Final Comments - PL 207-2018: MMC ST. John St Garage - Final Comments

These are my final comments in response to the revised plans submitted for the MMC Garage, dated 9/5/18:

Further revisions to the Site Layout and Material Plan 1 C-100 are to be made -

UTILITY PLAN - 1

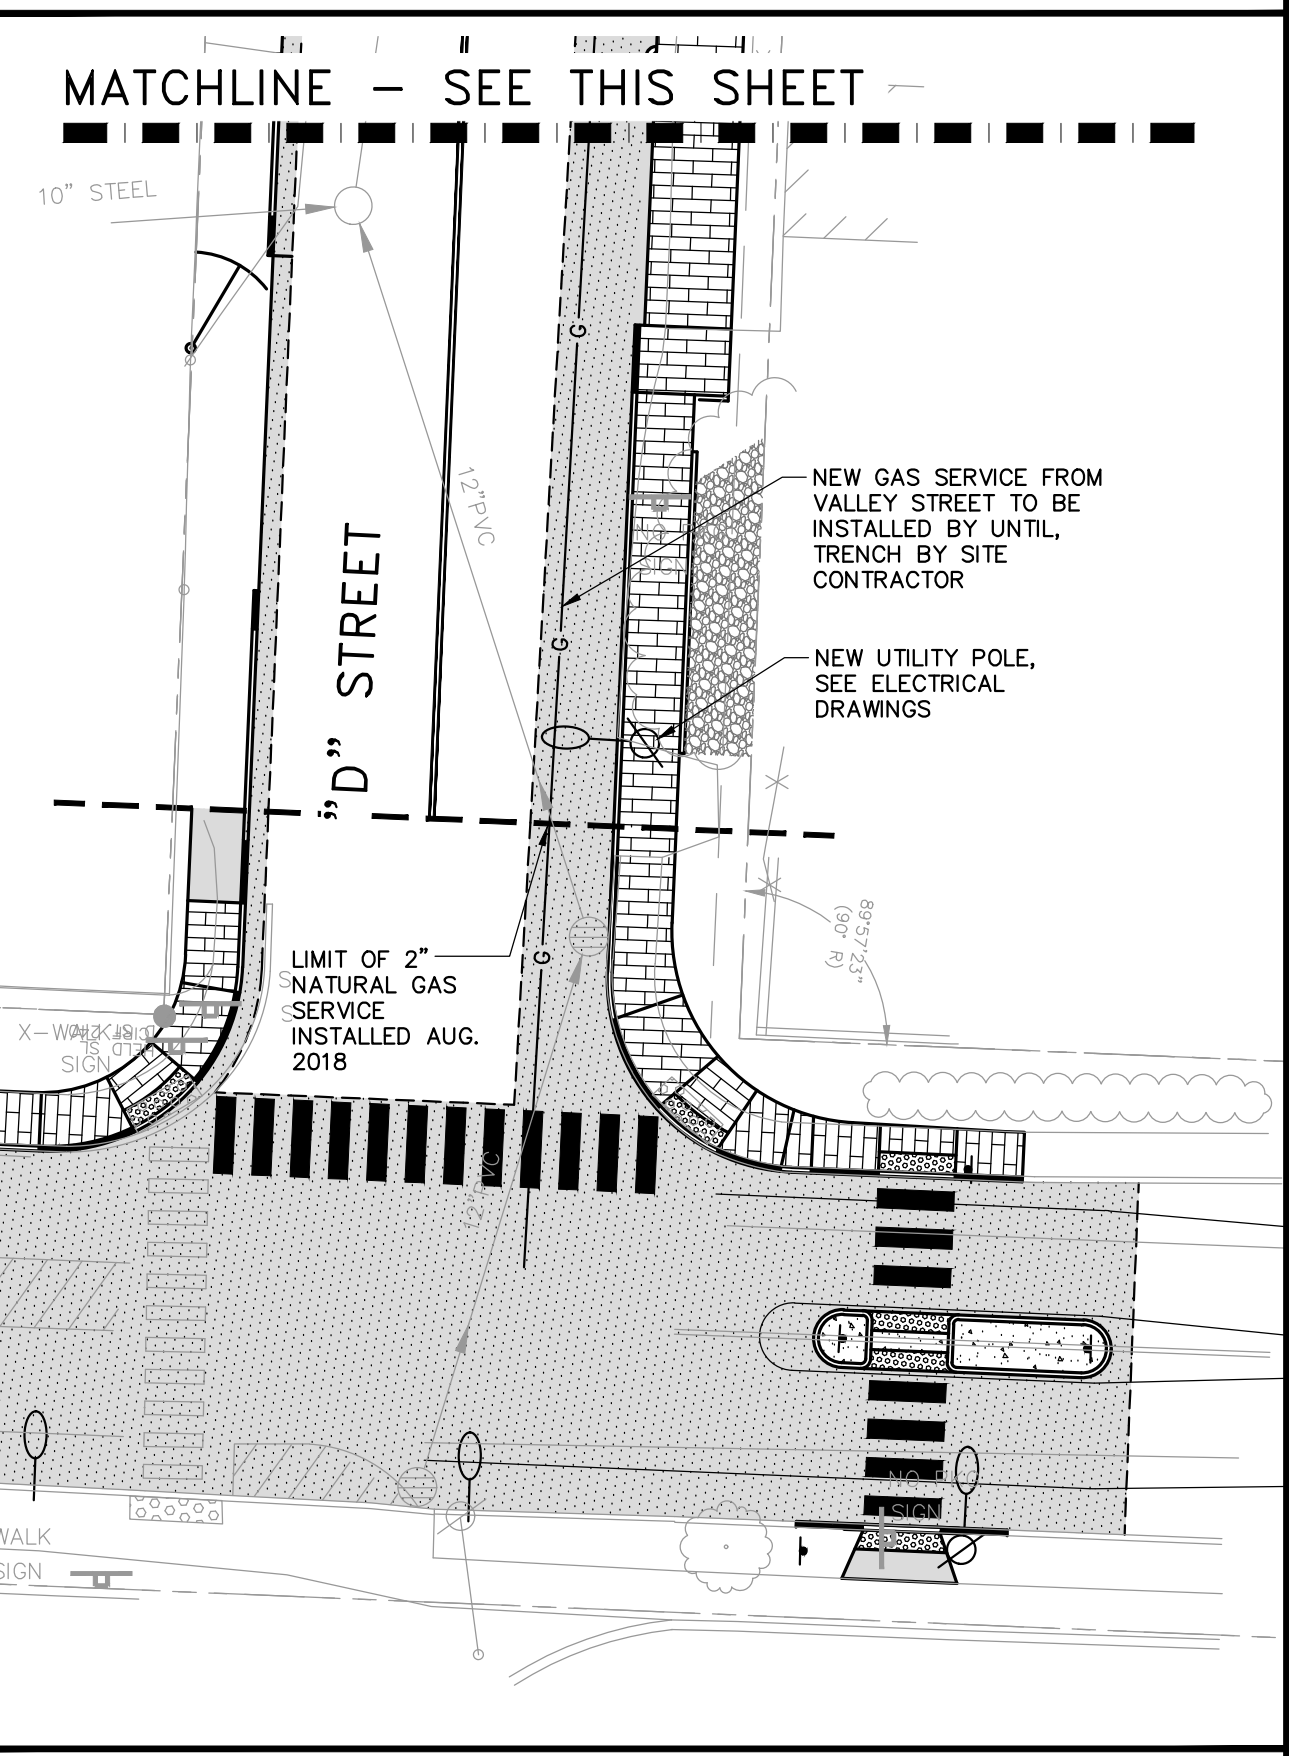
- the final Pavement Marking and Signage Plan(s) is to be revised and approved by DPW and the Planning Authority for corrections, including but not limited to correct
 - the striping around the refuge island on Valley Street
 - bike lane pavement markings on St. John Street
 - "Yield to Bikes" sign
- move label for CB30 on D Street to not obscure the light fixture
- revise the design of the curb ramp on the SW corner of St. John at the garage driveway to eliminate the skewed area with the vertical curb next to the ramp flares between the curb ramps
- the site plan is not consistent with C-104 Utility plan - the utility pole placement on C-100 on the SE corner is incorrect
